From: Stephen Gee [REDACTED]
Sent: 03 July 2020 10:42
To: Michael Eastham <Michael.Eastham@arun.gov.uk>
Cc: Planning.Responses <Planning.Responses@arun.gov.uk>
Subject: FW: Application Response Application WA/38/20/NMA

Location: Land East of
Tye Lane
Walberton

Proposal: Non-material amendment following grant of reference WA/44/17/OUT for the widening of the width of the road to make the emergency access wide enough for construction traffic. This access will only be temporary.

Drawing Title: TEMPORARY CONSTRUCTION ACCESS SWEEP PATH ANALYSIS

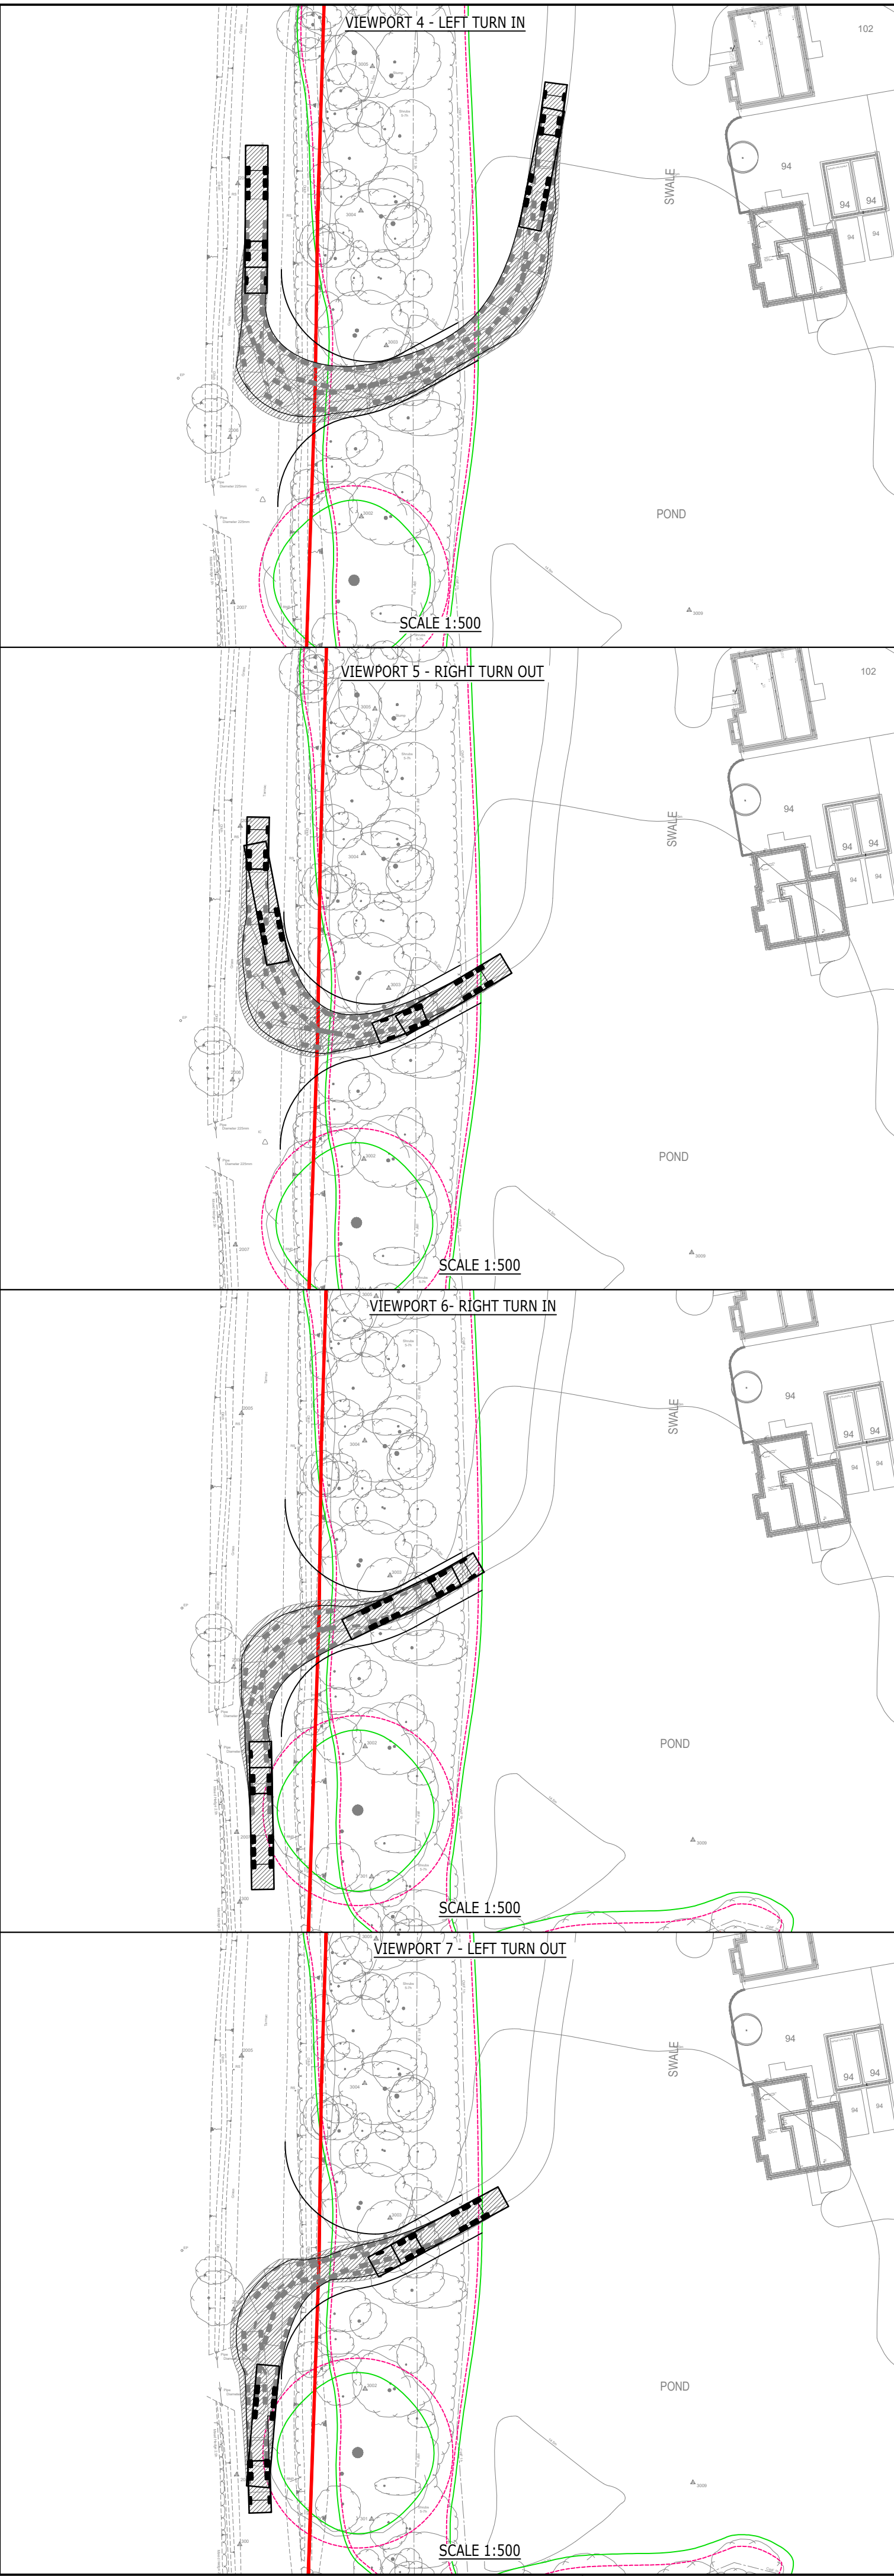
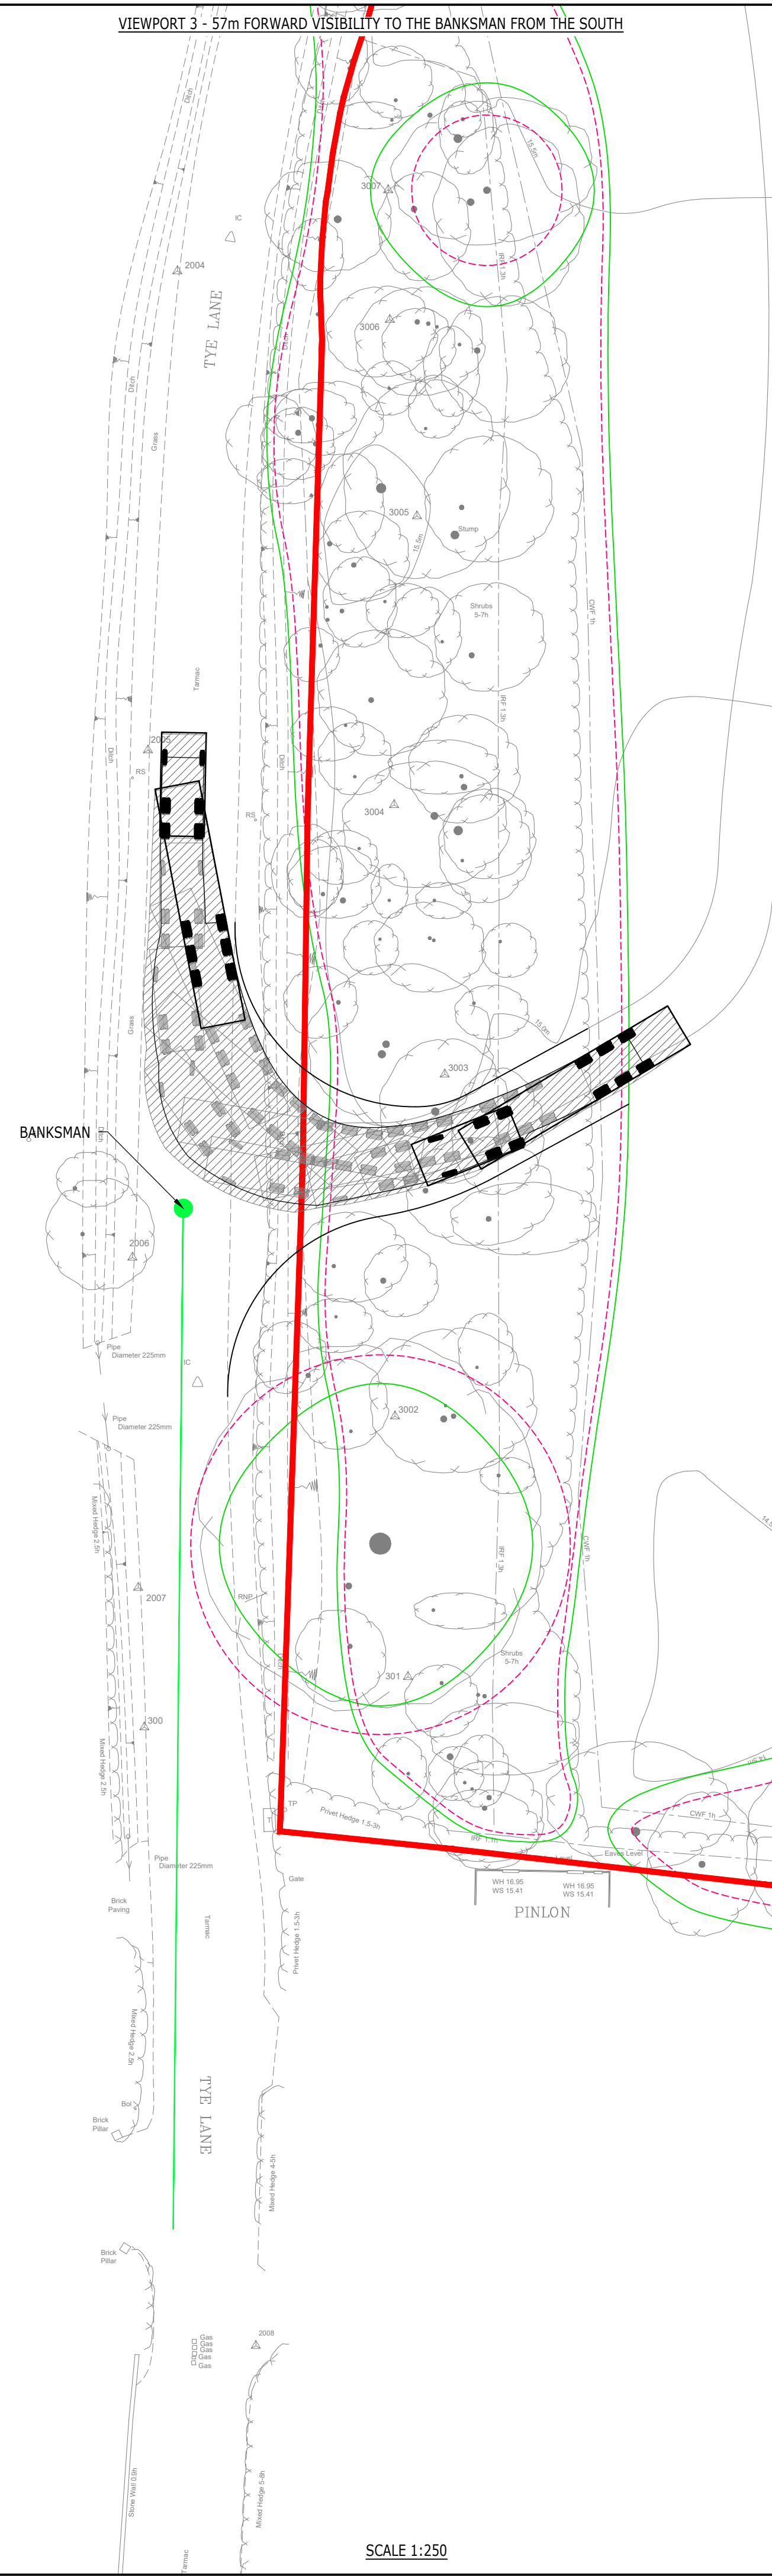
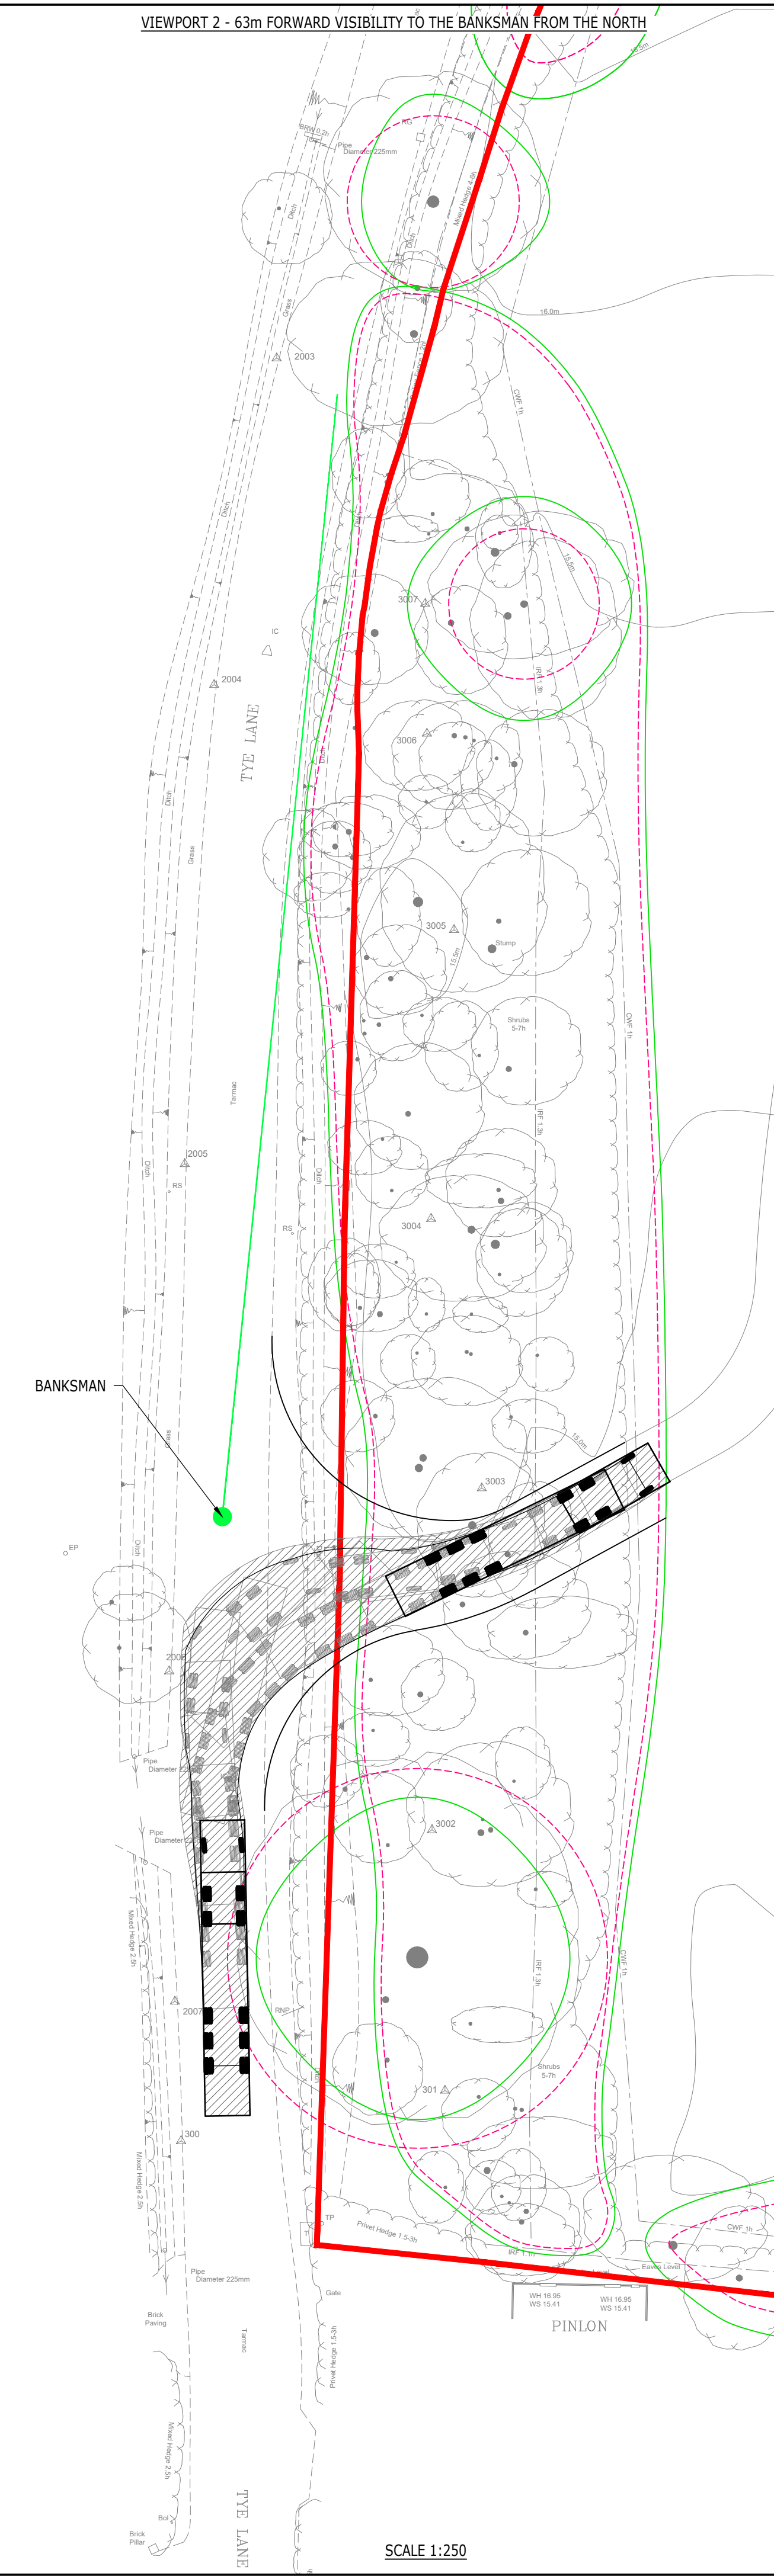
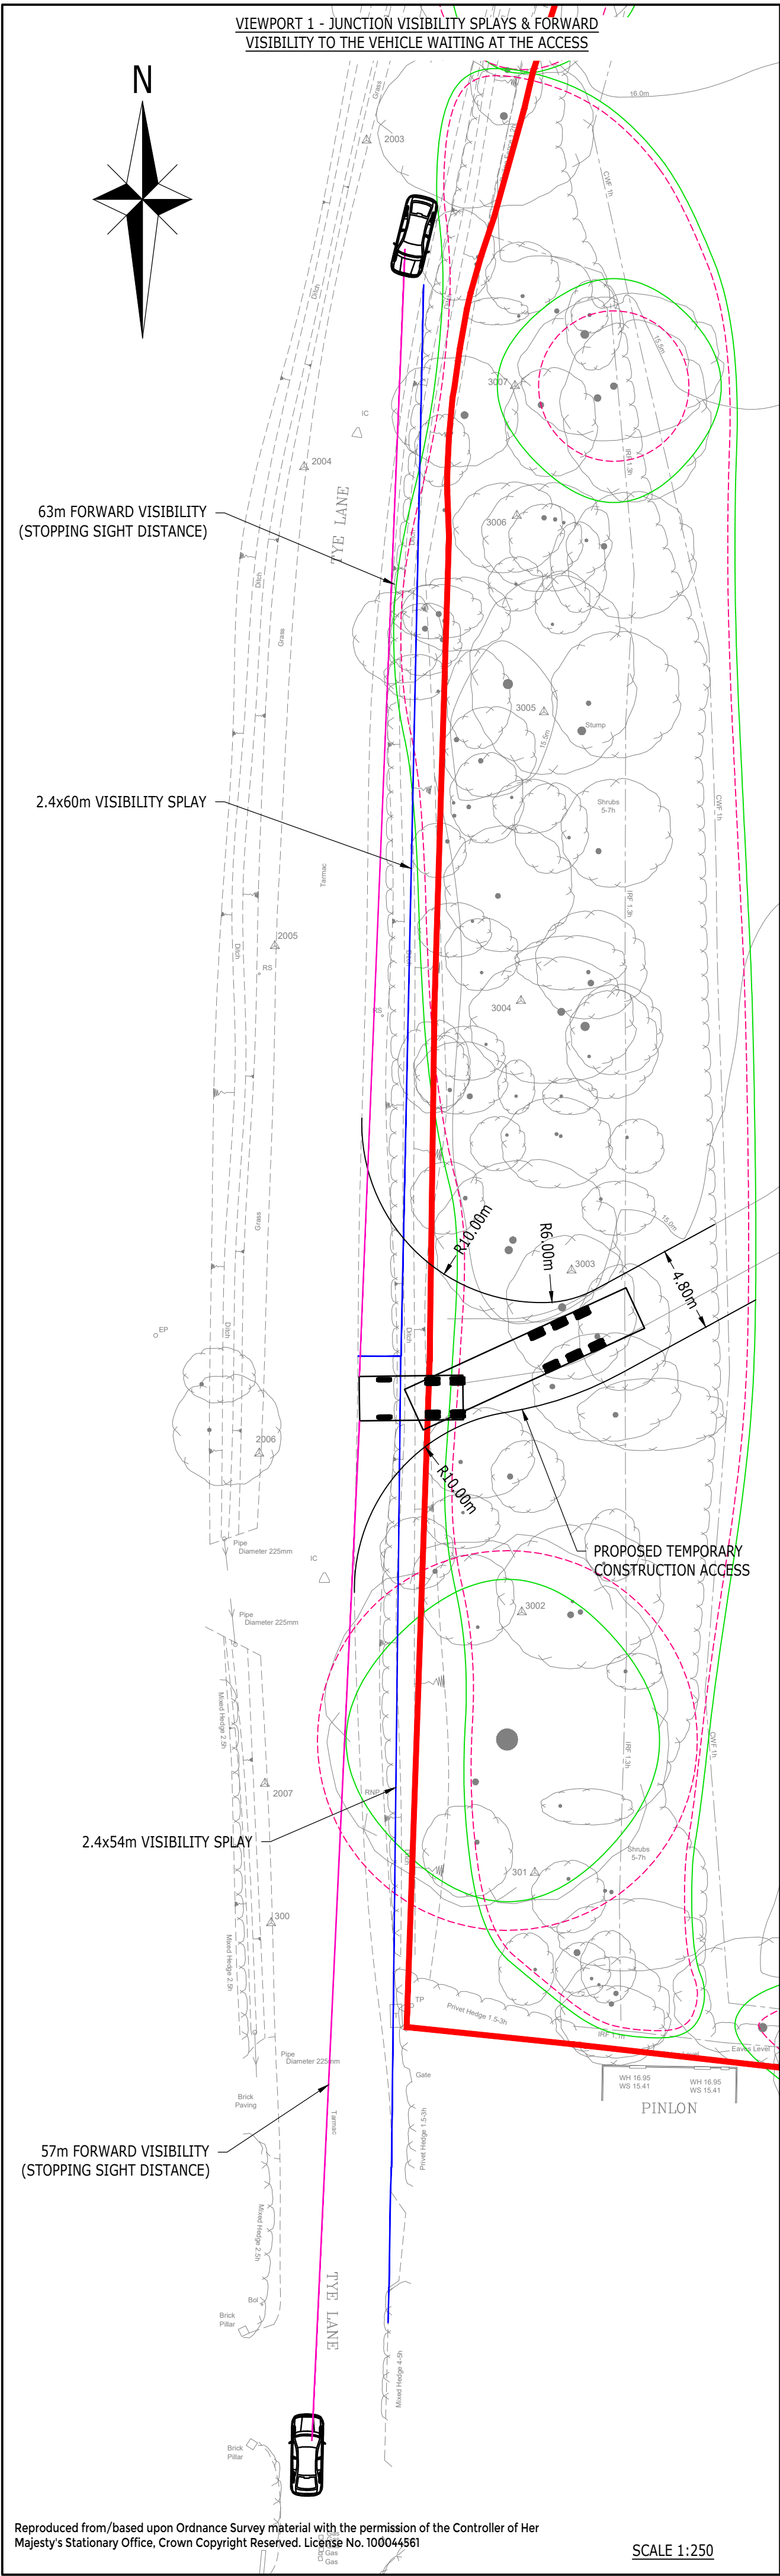
It is noted that drawing ref Temporary Construction Access Swept Path Analysis Dwg No 183244-001 shows the swept path for vehicles travelling north along Tye Lane (from Walberton Village) which would not be supported. Para 4.25 however confirms all movements would be via the A27.
